Application No: EP/71/26/HH
Site Address: 51 Warren Crescent East Preston BN16 1BL
Description of works: Extension to the side and infill extension to the rear, new roof and loft conversion and alterations to fenestration including removal of front porch.

Thank you for your internet representation made on 19th August 2026 which has been recorded as an objection with the comments as follows:

3 Proposed Block Plan

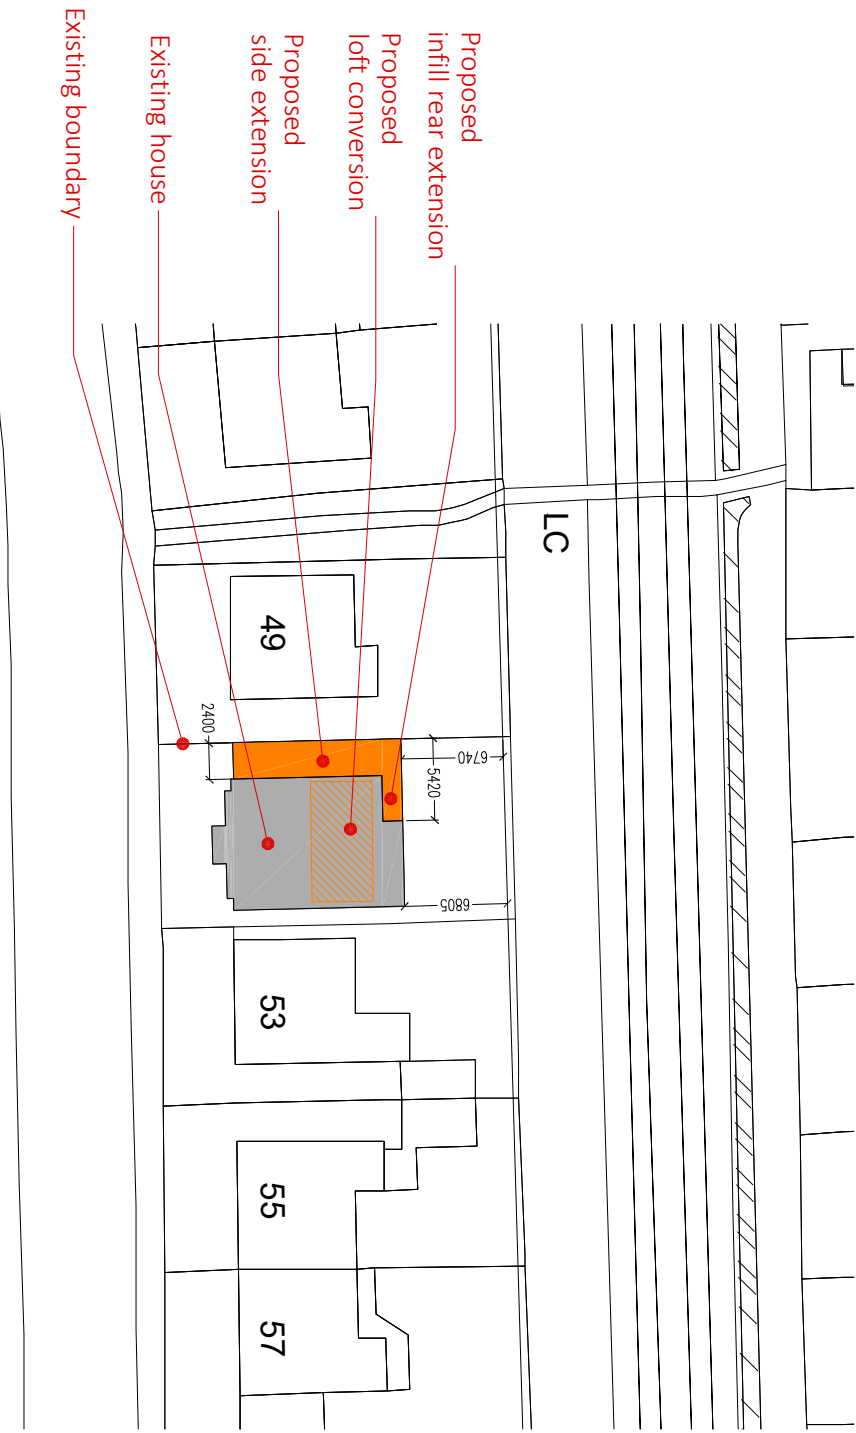
The proposed gable end with large dormers would be overbearing to neighbouring bungalows. The gable ends changes the appearance of the group of three bungalow with out any sympathy to the existing look. It is also shown that the roof hight would be higher than existing bungalows ether side or within the road. The gable end would be only 900mm from boundary of 53 Warren Crescent (measured) not as shown on the scaled drawings.
